Application no: H03/0854/01

Description: Proposed garage with games room above (re-submission of H03/0195/01)

Amendment: Change from block & render to bricks - Istock Yellow Stock

TOWN AND COUNTRY PLANNING ACT 1990
NOTICE OF ACCEPTANCE OF AMENDMENT

Dwg. No.
2321/4

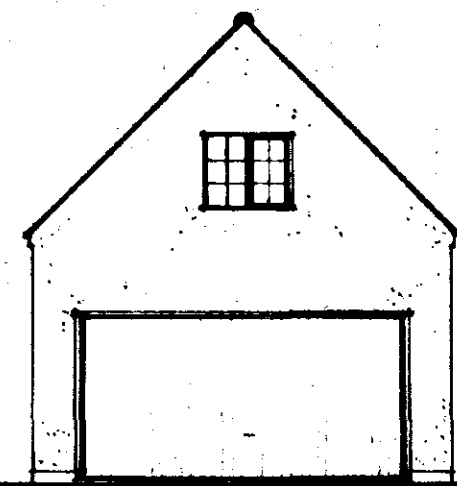
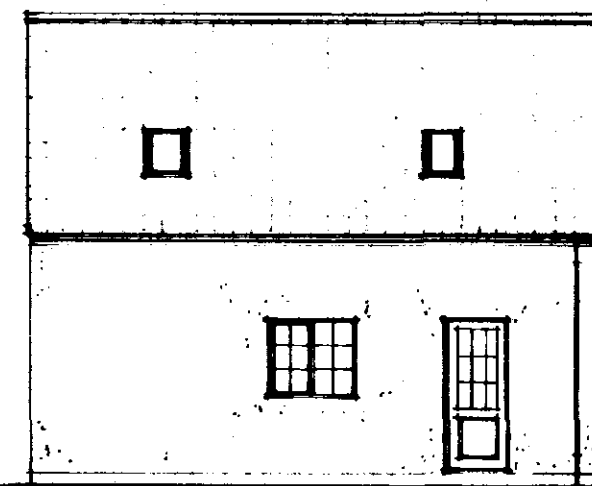
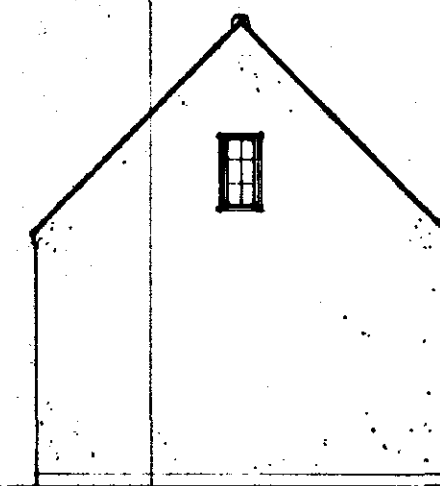
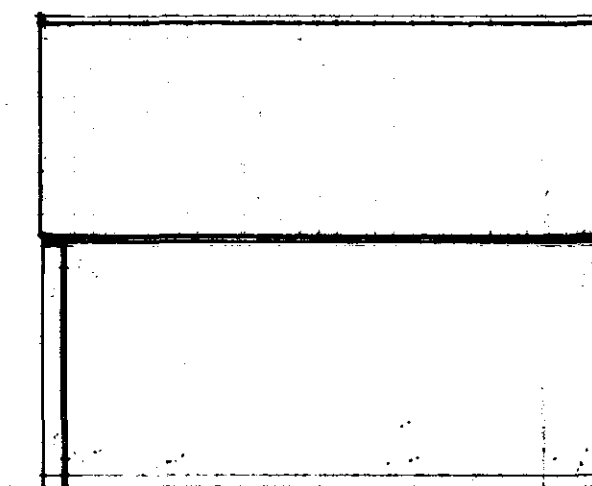
Following our recent telephone conversation, we confirm that we wish to change the above build construction from block & render to facing bricks. The bricks we wish to use will match the existing single storey extension and are Istock Yellow Stock, Code LE013471A.

The amended details submitted in respect of the above proposal have now been considered and there are no objections to the amendment being implemented to the extent described above.
